Application Reference: 2025/0766

Site Address: 185 Burton Road, Monk Bretton, Barnsley, S71 2HG

Introduction: Removal of existing garage and erection of single storey side extension and alterations to detached bungalow

PROPOSED FRONT ELEVATION

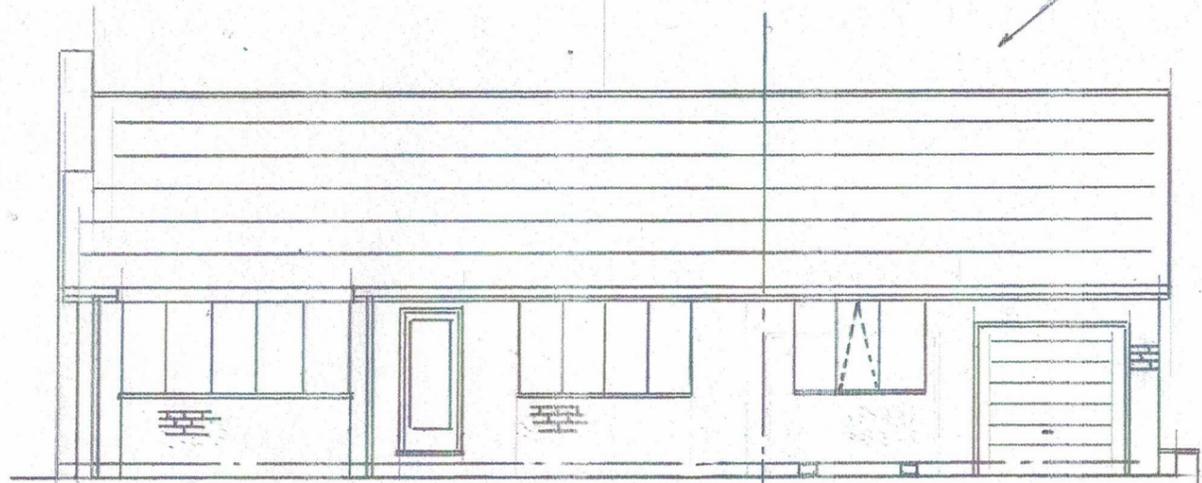
The front elevation is detailed to be rendered in a 'Permarock Brick Effect' which should provide a similar visual appearance to brickwork and allow the front elevation of the property to remain in keeping with the character of the street scene. In order to ensure the 'Brick Effect' would be completely in keeping, a condition will be added to be discharged prior to commencement to check the colour and details of the 'Permarock Brick Effect'.

It has been necessary to make contact with the applicant to clarify the works would not be erected on the boundary wall to the south of the site. Amendments were also requested to alter the materials to the front of the dwelling to be more in keeping with the character of the street scene.

PROPOSED GROUND FLOOR PLAN

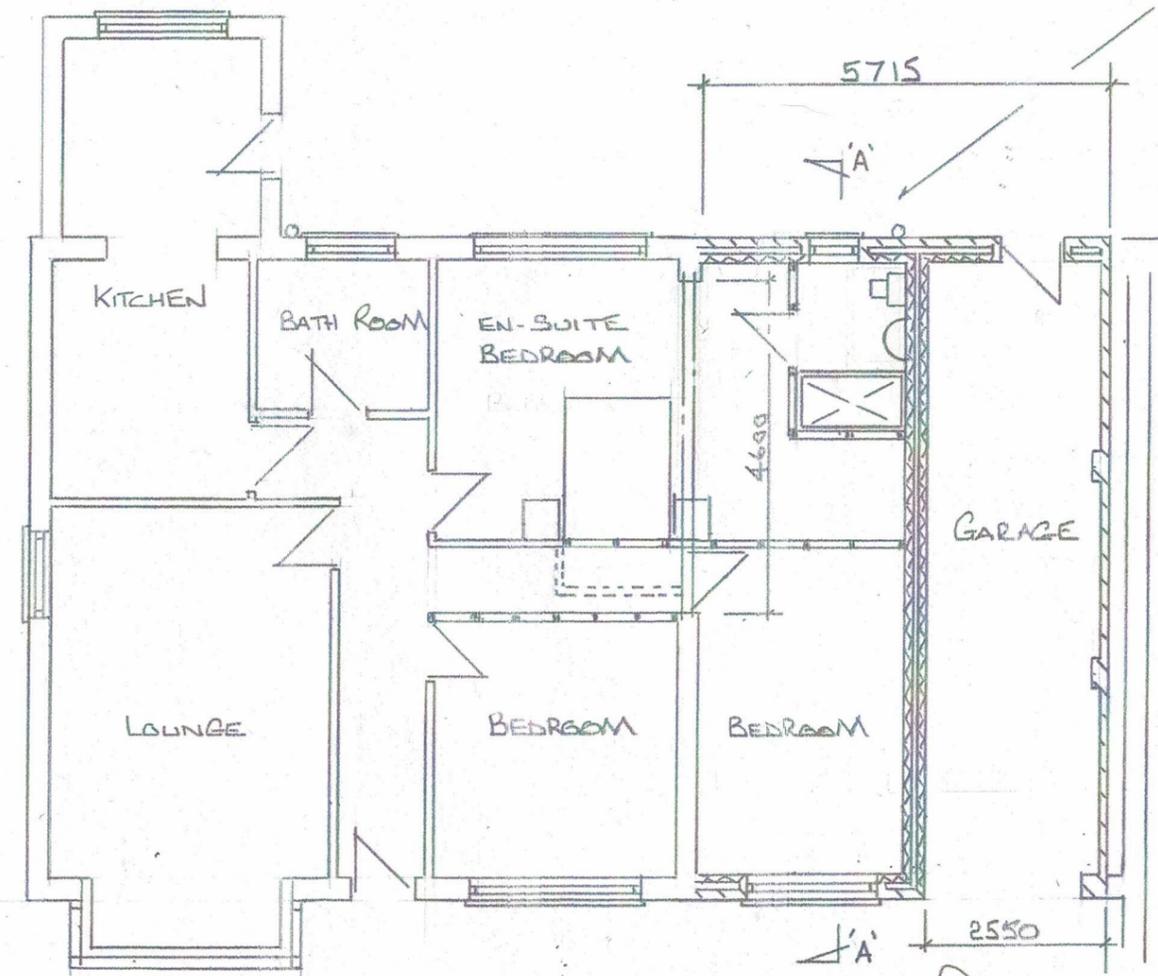
One representation has been made objecting to the position of the extension resulting in foundations in close proximity to a 'load bearing wall' and requesting the proposal be moved 1 metre away from the wall. Request was also made to ensure the wall would not be damaged and that any damages would be paid for by the applicant. It was also outlined that no access to maintaining the extension would be given by the objector.

The representation made in reference to ensuring the proposed works would retain the structural integrity of the retaining boundary wall would not be a material planning consideration. This would be a concern for building control to ensure the proposal is built to the relevant structural standards. A request was made from the objector to move the proposal 1 metres away from the boundary wall but the above assessment shows the scale of the proposal to be acceptable and would be compliant with the House Extensions SPD and is therefore considered acceptable. Additionally the proposal would not detrimentally impact the residential amenity of neighbours and therefore would not require any reduction in proximity to boundaries. Furthermore, any repairs to damage to the wall would not be something which can be conditioned under a planning application decision as this would be a civil matter between the two parties. The applicant has signed certificate A on the planning application from which outlines the land within the red line boundary is owned by the applicant and therefore no permission from a third party for the work is required. Informatives will be added to the decision notice to inform the applicant that the permission provided does not infer any consent of any other landowner and that any permission does not grant any permission for works on land not under the ownership of the applicant.
